Landscape Plan Drawings_V1 redlines.pdf Markup Summary

4/21/2022
American Dog Pros Site Plan
Chris Dunlap 719 287-1449
pinnacleK9training@gmail.com

12900 Murphy Rd
Elbert, Co
Property Tax Schedule # 4132000009

Vicinity map showing the subdivision in relation to section lines and existing or proposed arterial or collector roadways

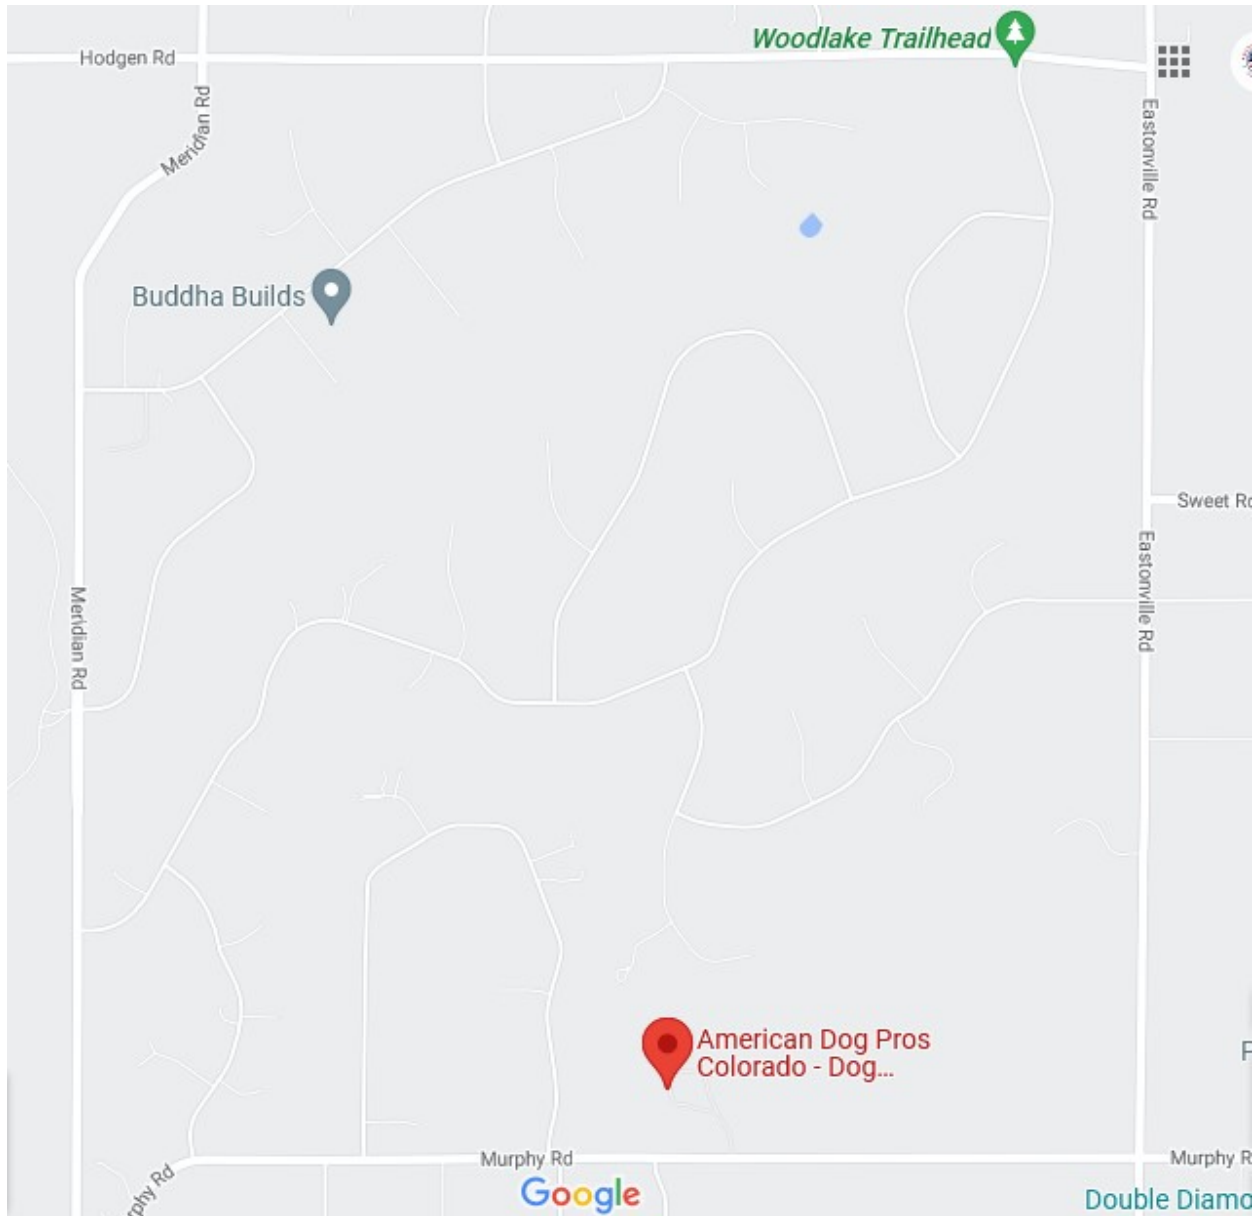
Per SDP checklist, provide parking calculations (e.g., required versus proposed). Also need to provide open space, landscaping, and impermeable surface percentages.

Footprint of all existing and proposed buildings and the setback distances from each existing and proposed structure to the property lines. No sidewalks.

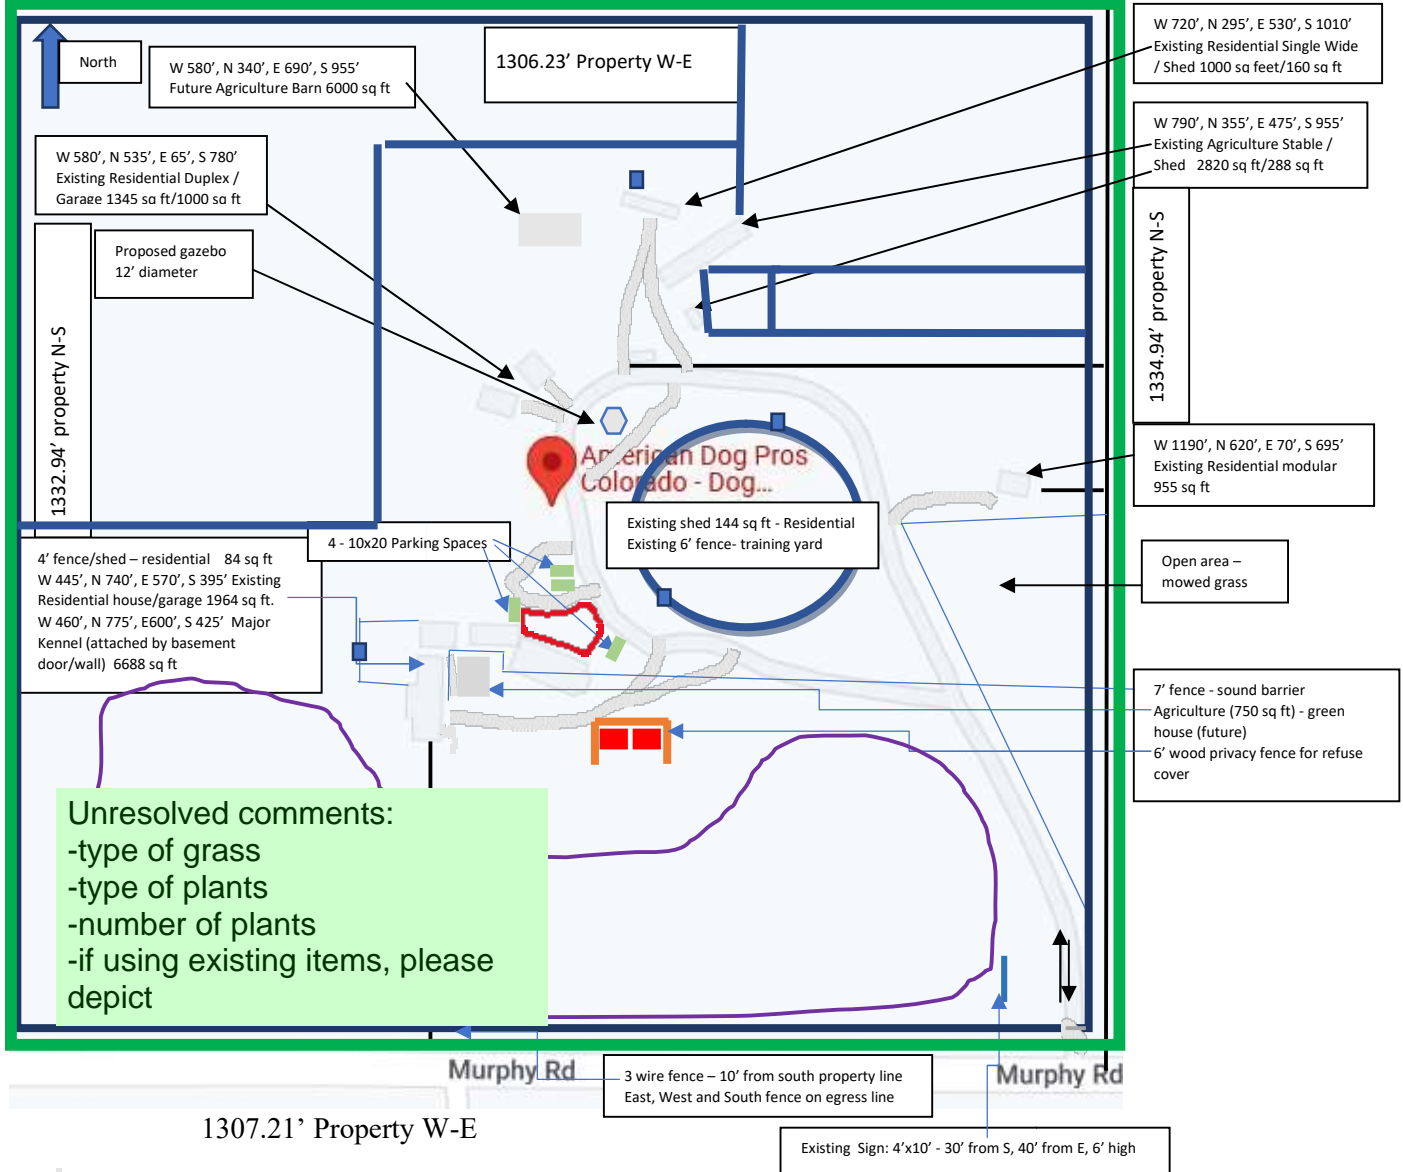
Please show location of future fence as described in the sign plan.

Per SDP checklist, please provide a graphical depiction of the screening mechanism for the trash receptacle.

Please clarify if this is an existing or proposed sign.

Provide setback distances from existing and proposed structures to all property lines.

Is this 76' from the southern property line?
